**Council submission re: Macquarie University Central Courtyard Precinct Redevelopment  
192 Balaclava Road, Macquarie Park (SSD 8755)**

Council has reviewed the DA documents attached to the notification letter and makes the following comments recommended conditions of consent for the consideration of the DPE prior to making a determination of the DA:

**Figure 3 – MCC Construction Vehicle Access Routes**

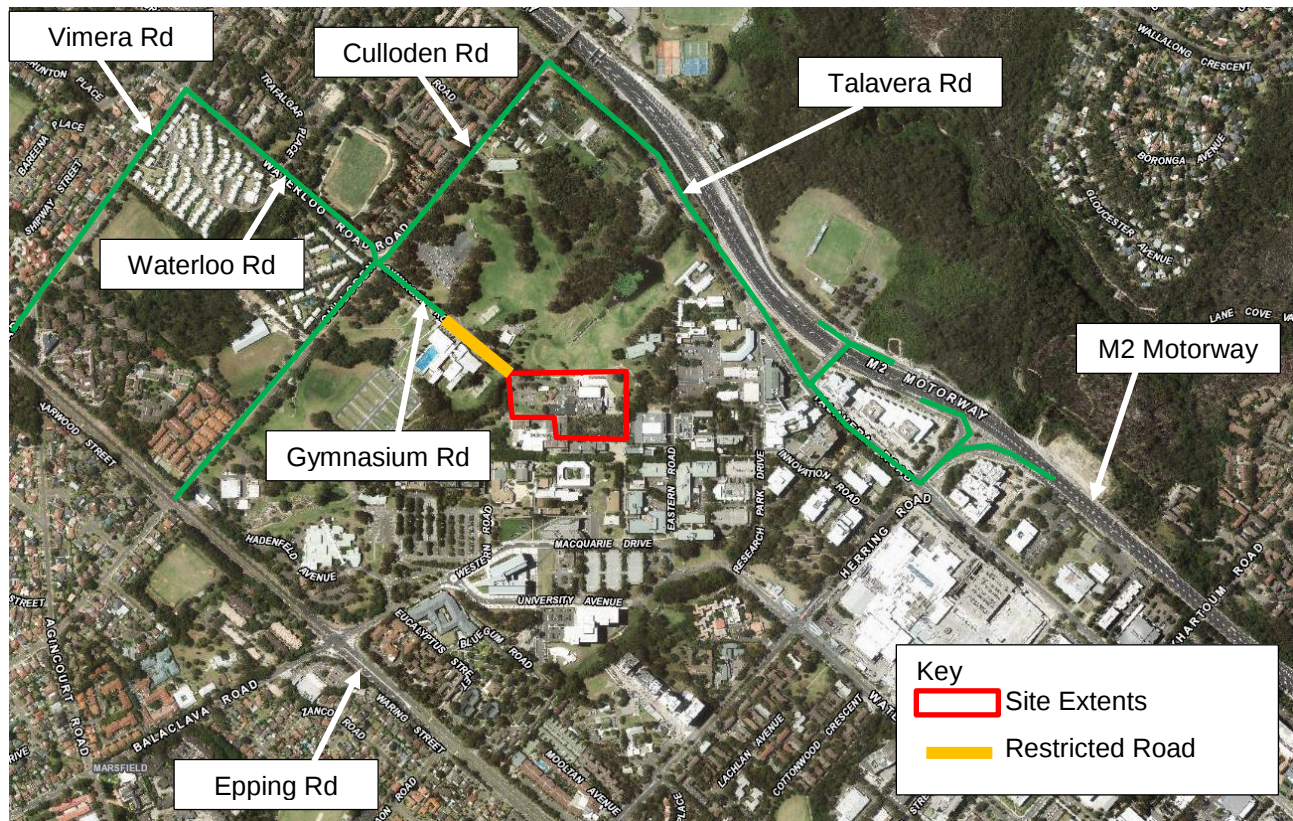
Turning paths of construction vehicles were provided only for Culloden Road / Gymnasium Road intersection.

5. Plans should be amended to show the swept path provision for all local road / local road intersections that are part of the proposed truck routes. This must be included in the CTMP.

The traffic report proposes to "Permit construction vehicles only to turn right from Culloden Road to Gymnasium Road" during construction. This must be justified or clarified considering Gymnasium Road provides access to several car parks. It is Council request that this matter is clarified prior to issue of any development consent.
